Consultation Response from KC, Conservation and Design		
2021/93007 Yew Tree Farm, 63, The Village, Farnley Tyas, Huddersfield, HD4 6UQ		
Listed Building Consent for conversion of existing barn to form 8 dwellings, erection of 10 dwellings, demolition of redundant agricultural buildings and associated works (Listed Building within a Conservation Area)		
Date Responded: 7.10.21	Responding Officer: Sue Brooks	Responding Ref:

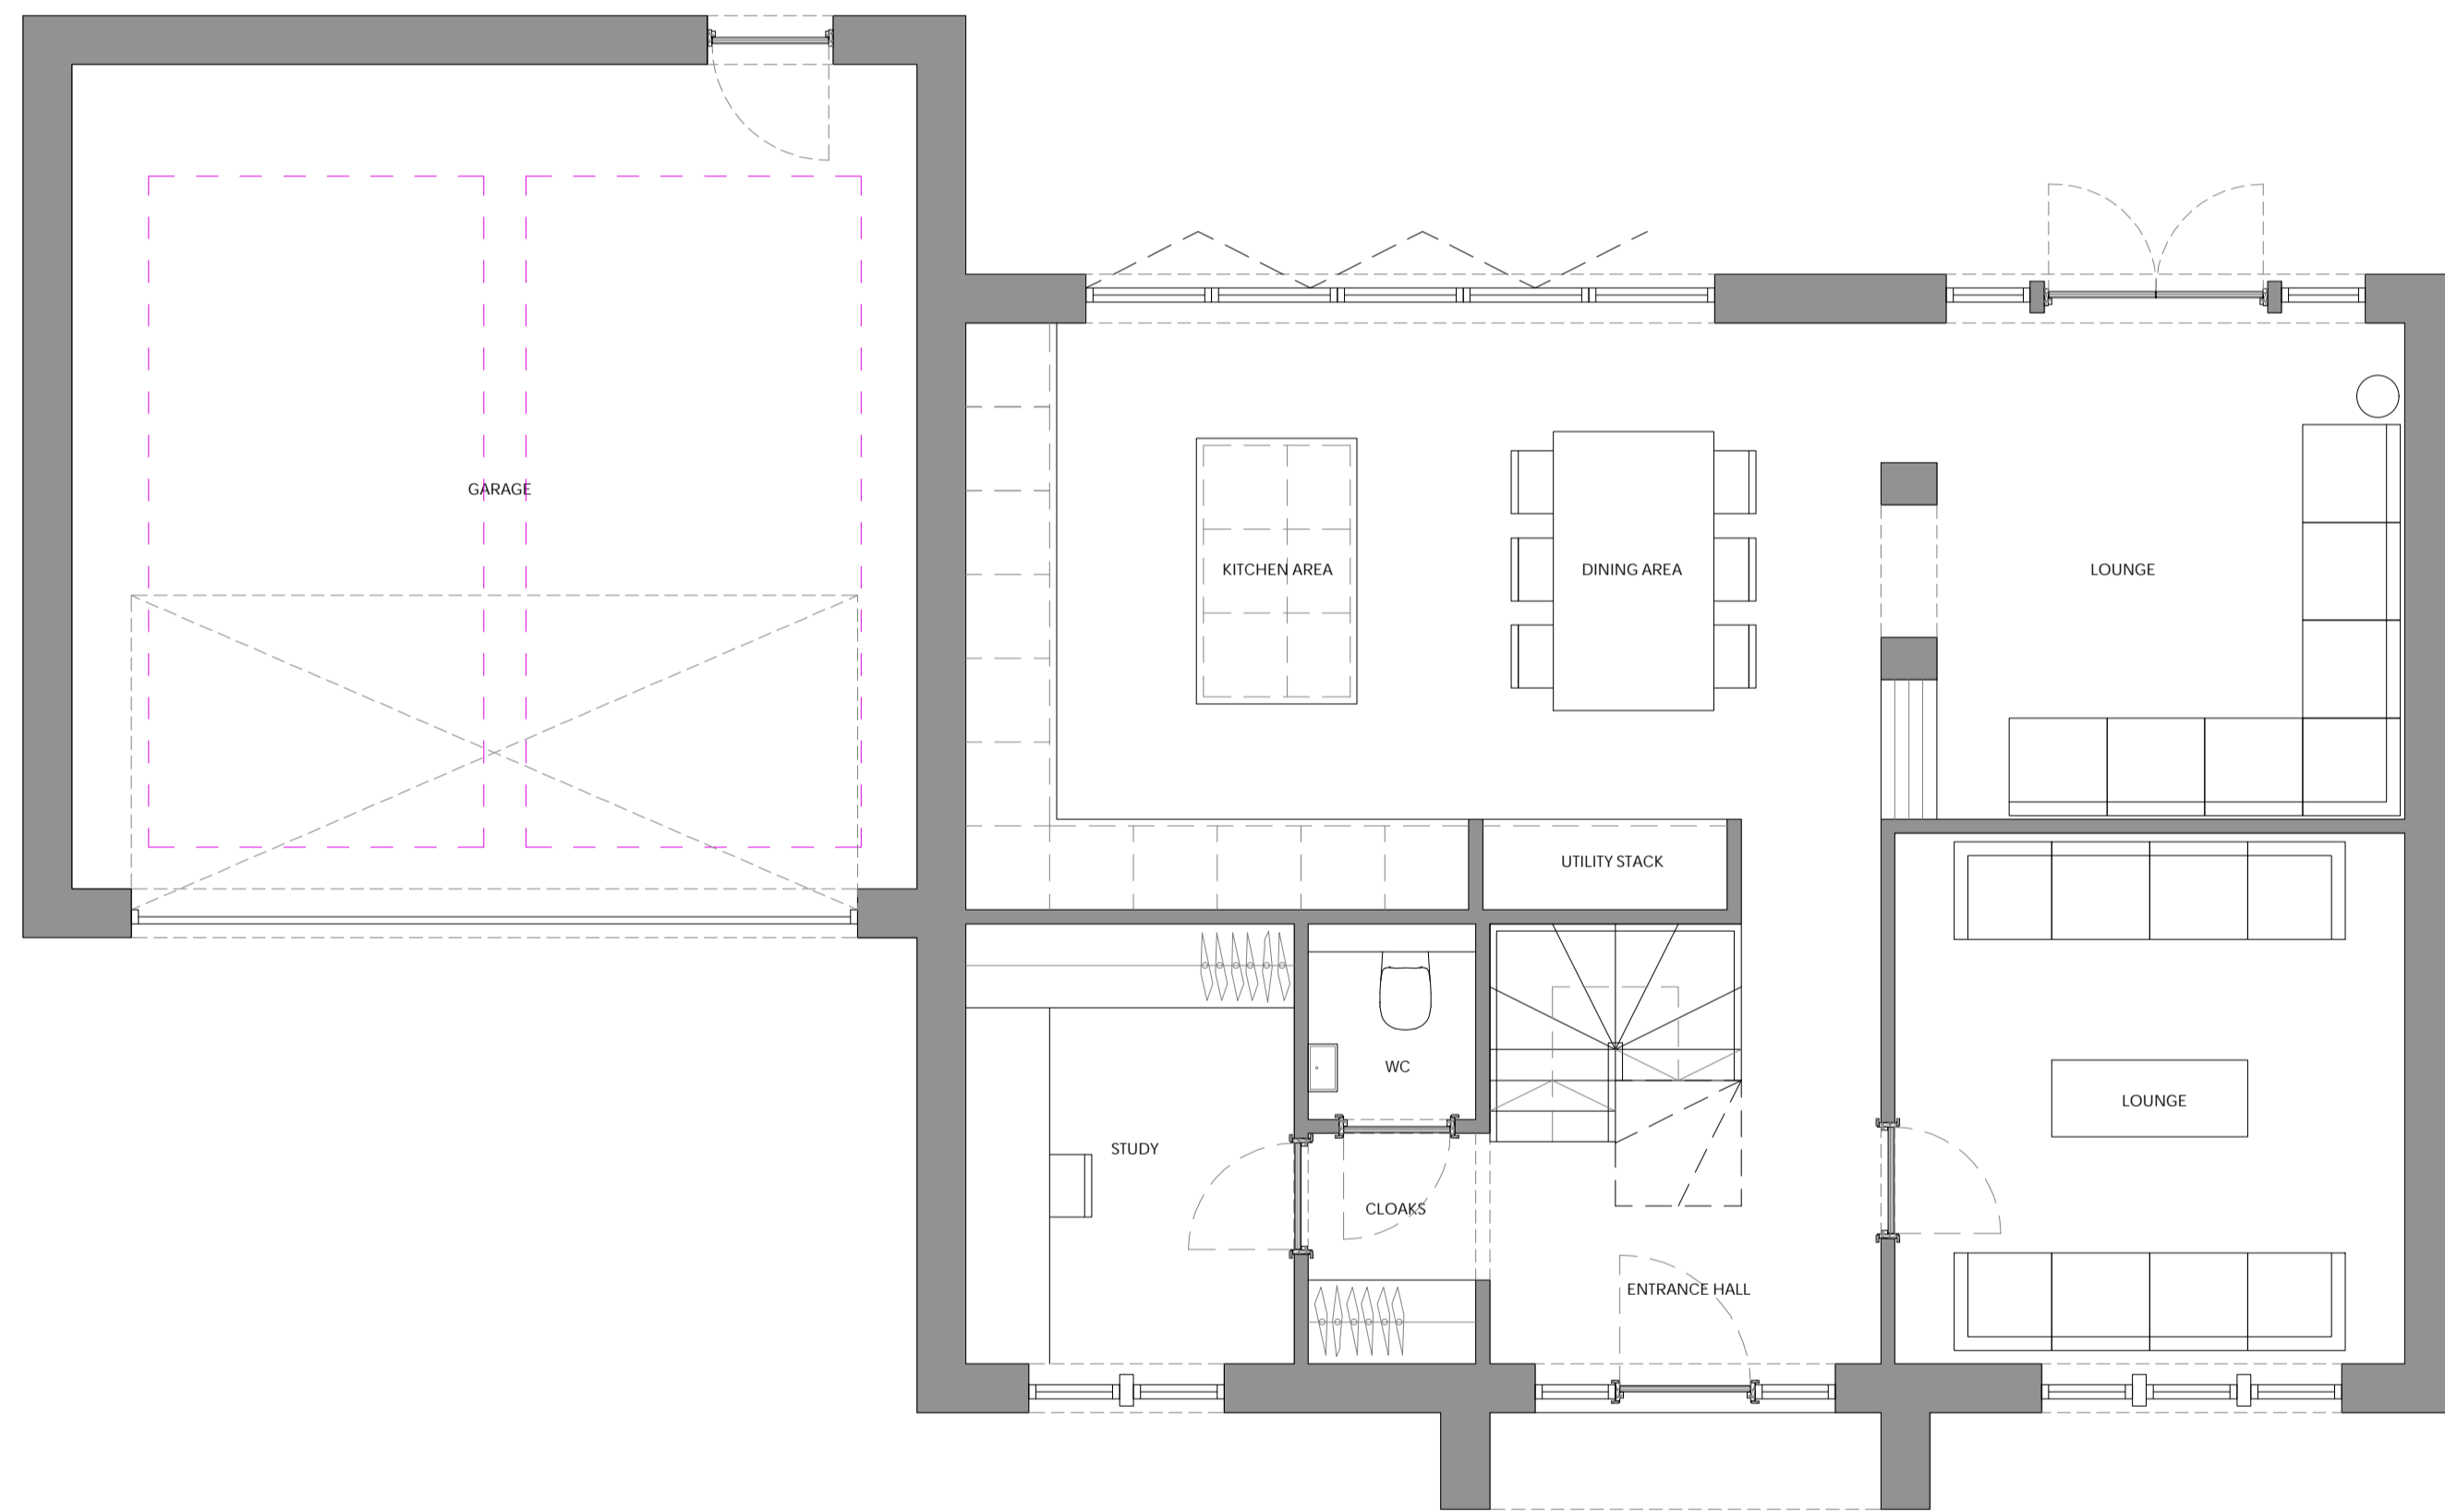
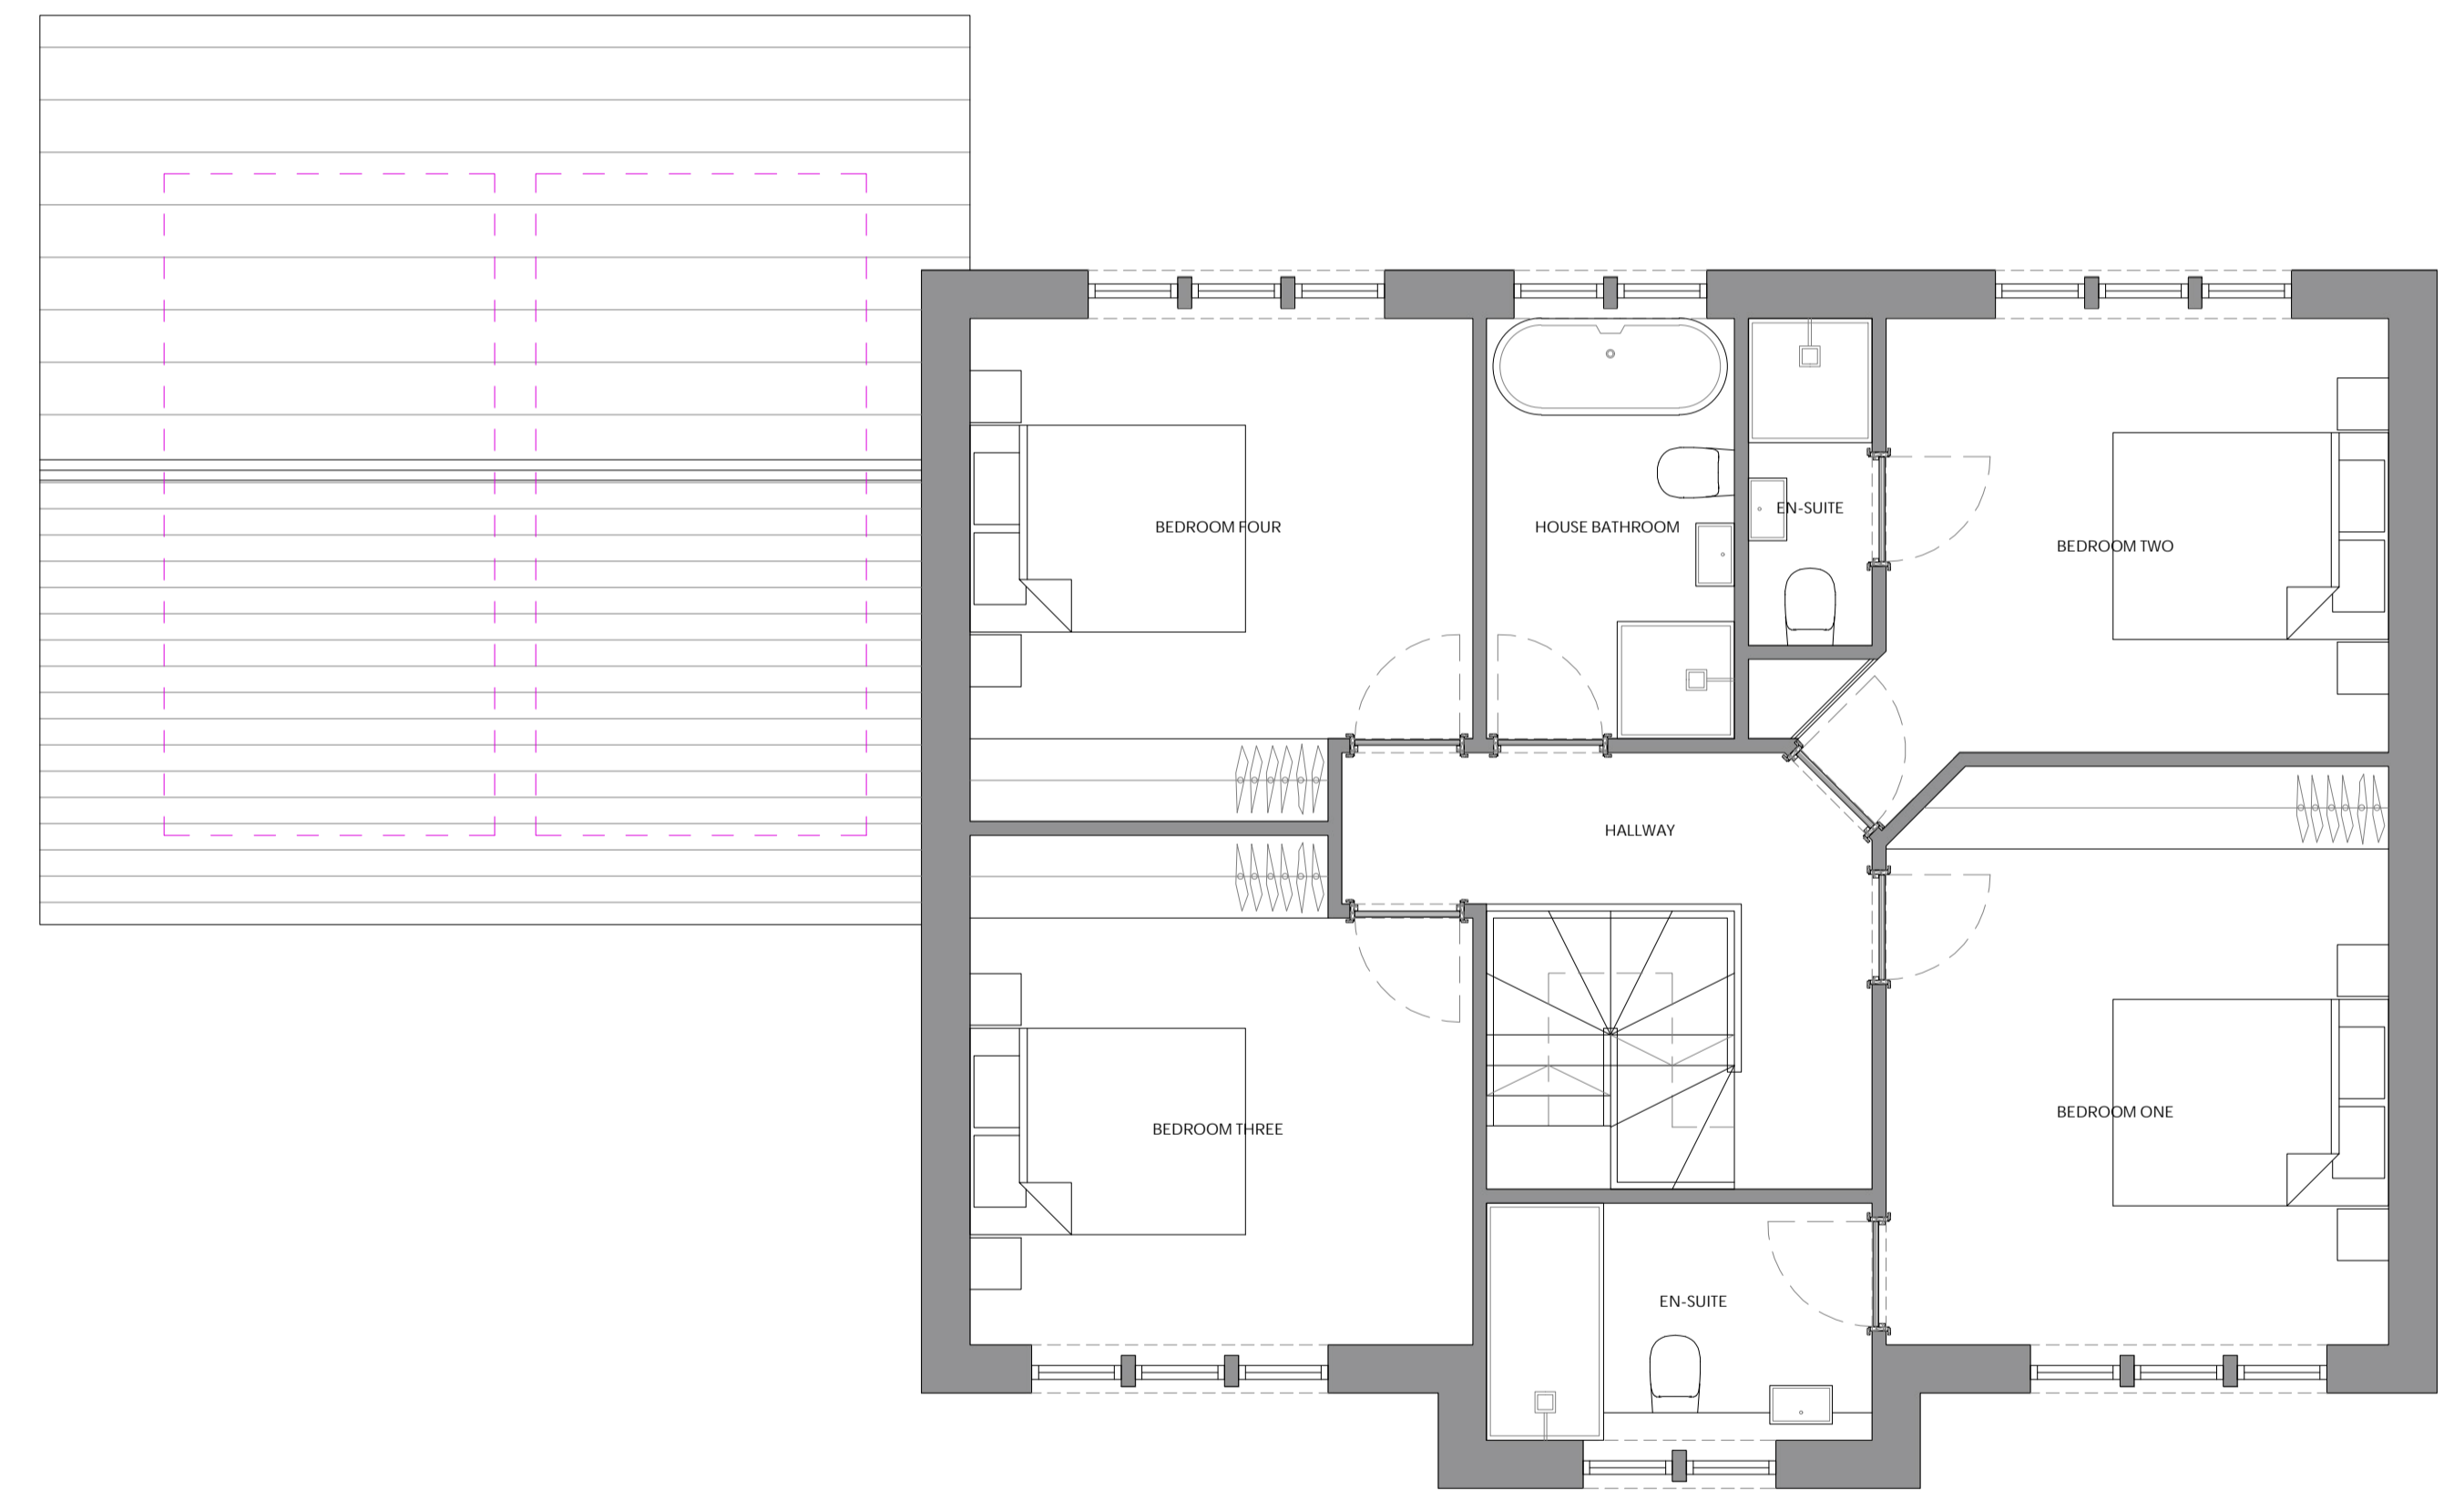
Plot 17 (house type 4) is proposed in the design pack as a replacement for this house 'to create a similar character to the existing building.' The proposed building is of a similar scale to the curtilage listed house; however, the context and fenestration are quite different, and the construction of this new house does not justify the loss of a historic building.
